16 December 2020

Melissa Anderson  
Environmental Assessment Officer  
Resource Assessments  
NSW Department of Planning, Industry and Environment

**Modification Application and Statement of Environmental Effects (SEE) for the Chain Valley Colliery - Modification 4 (SSD-5465) – EMIN20-00012**

Figure 2: Proposed mine design changes

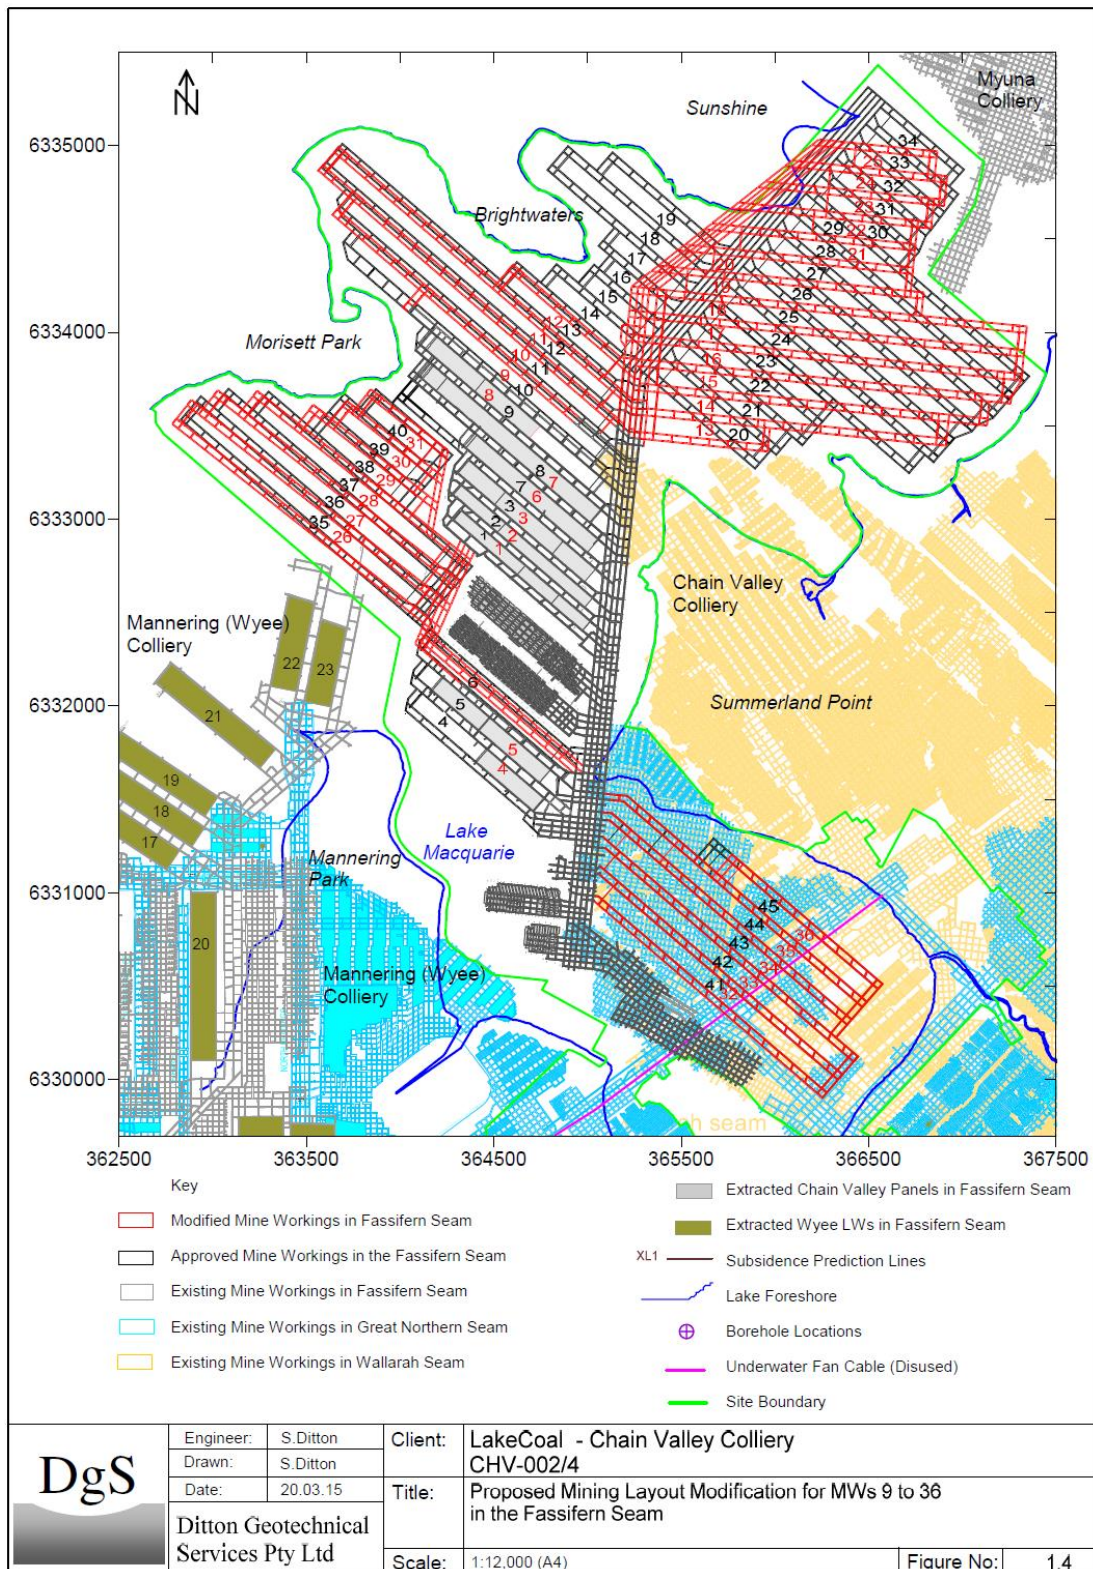
SA NSW also understand that previous conditions of consent in the proposed extension area restrict surface subsidence impacts to 20mm total vertical subsidence. Due to the impact to residential development should an unplanned subsidence event occur, SA NSW recommend that both the proposed mine layout and the accompanying assessment of pillar stability be reviewed by a suitable industry recognised expert.

It is recommended that the review include an assessment on whether the following has been adequately addressed;

- The potential for bearing capacity failure of the roof or floor causing additional/unplanned subsidence.
- Whether the pillar plan dimensions on which the assessment is based, accurately reflect the dimensions that can be achieved operationally using standard mining equipment (continuous miner).
- Whether long-term stability of the proposed pillar system has been adequately considered, taking into account spalling and flooding of the workings over time.
